Subject: FW: Application Y/103/18/PL Crematorium Proposal, Grevatts Lane West

From: Stephen Gee
Sent: 14 February 2019 14:11
To: Simon Davis <Simon.Davis@arun.gov.uk>
Cc: Planning.Responses <Planning.Responses@arun.gov.uk>
Subject: RE: Application Y/103/18/PL Crematorium Proposal, Grevatts Lane West

PBA drawing 128.001.007 Rev D

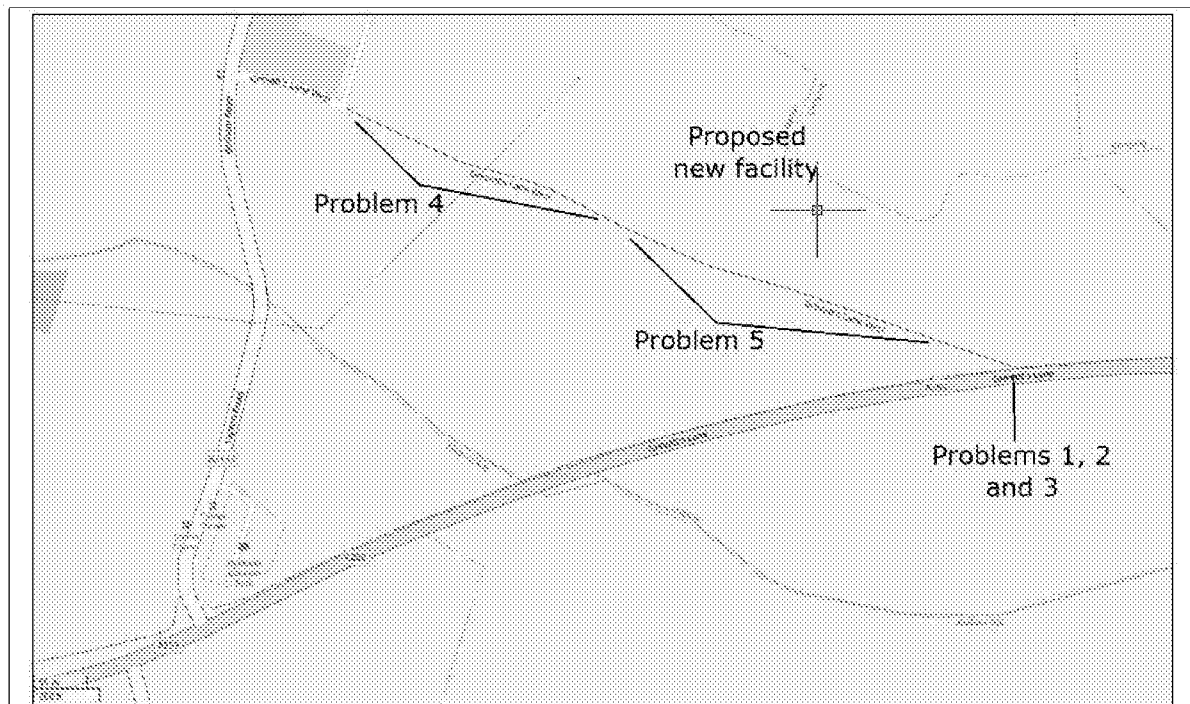
With regard to Stephen's first point, I do not read the Safety Audit as making changes to the access arrangements. The page on which the plan in question sits is labelled as "Site Location Plan" and the drawing itself seems to be a composite of the plans already given to us. However, there is a reference on the plan which says 128.001.007 Rev C "Access Road Amendments" and the version of this drawing that we have in the application files (forming part of the TS) is Rev A. Therefore, can you explain whether the access arrangements have been changed and if so send us the new plan along with the other information Stephen has asked for.

Simon,
It is noted that the applicant has revised the access proposals and access onto the A259 however the only indication of this I have is the low quality drawings provided at the end of the safety audit.

These plans should be submitted. I would also highlight the requirement for additional information from my initial response (replicated below)
